**CITY OF PORTLAND, MAINE
DEVELOPMENT REVIEW APPLICATION
PLANNING DEPARTMENT PROCESSING FORM
DRC Copy**

January 14, 2005

RE: Application for Single Family Residence, Longview Drive, Auburn Estates Lot #8

LEFT ELEVATION

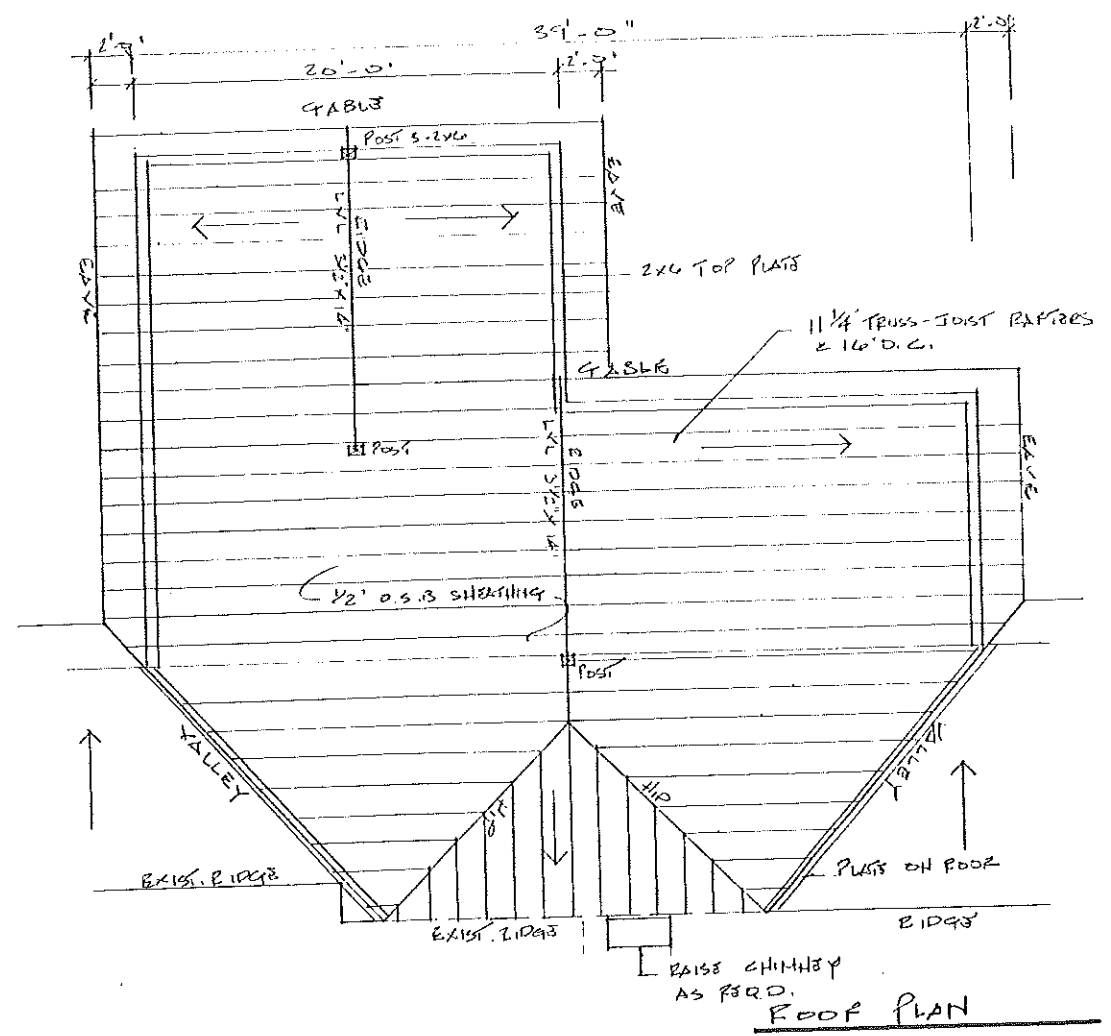
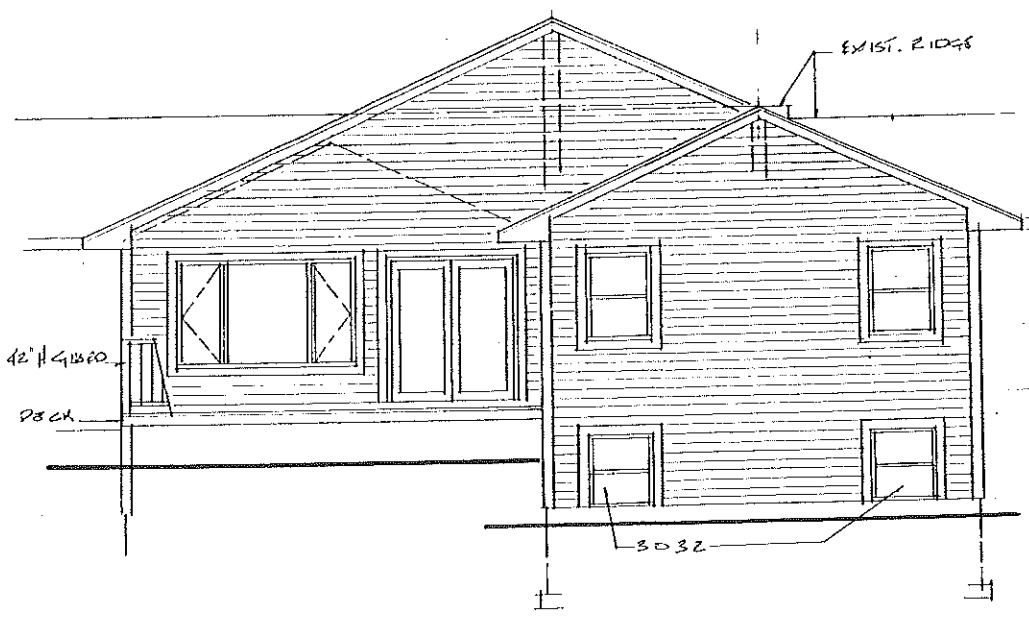
1. The Proposed finish floor elevation and garage floor elevation do not match the building elevations submitted. The site plan, which is the same as the approved subdivision plans, show a 9-foot elevation difference between house finish floor and garage floor. The building elevations do not reflect this.

RIGHT ELEVATION

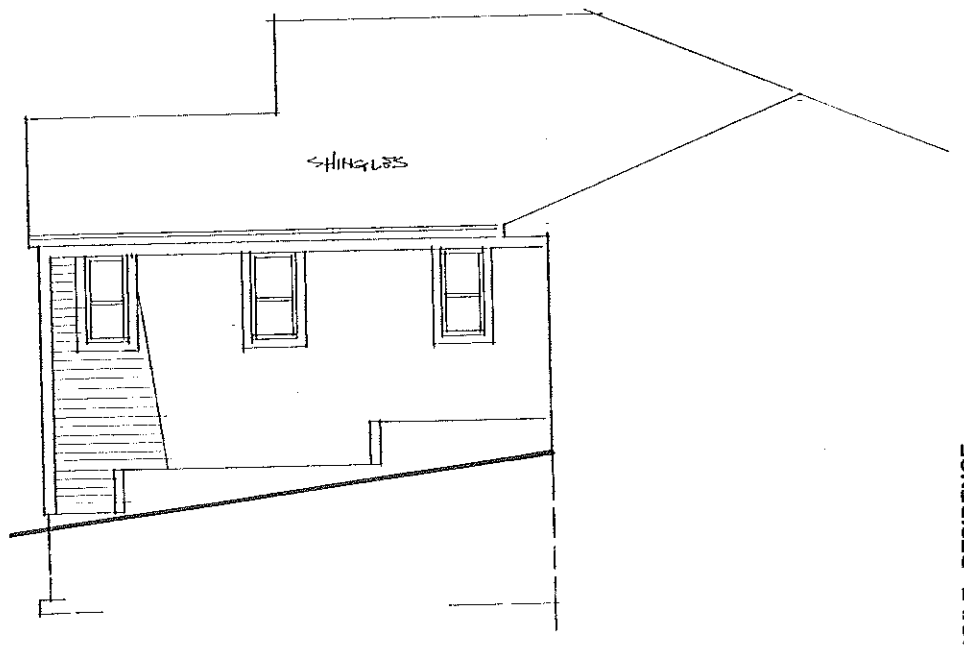
I've attached the recently approved site plan for lot #7. This application involved re-designing what was originally approved. Lot #7's elevations and new topography may help in re-designing your lot. It will also be important to show how the topography will match at the side property line.
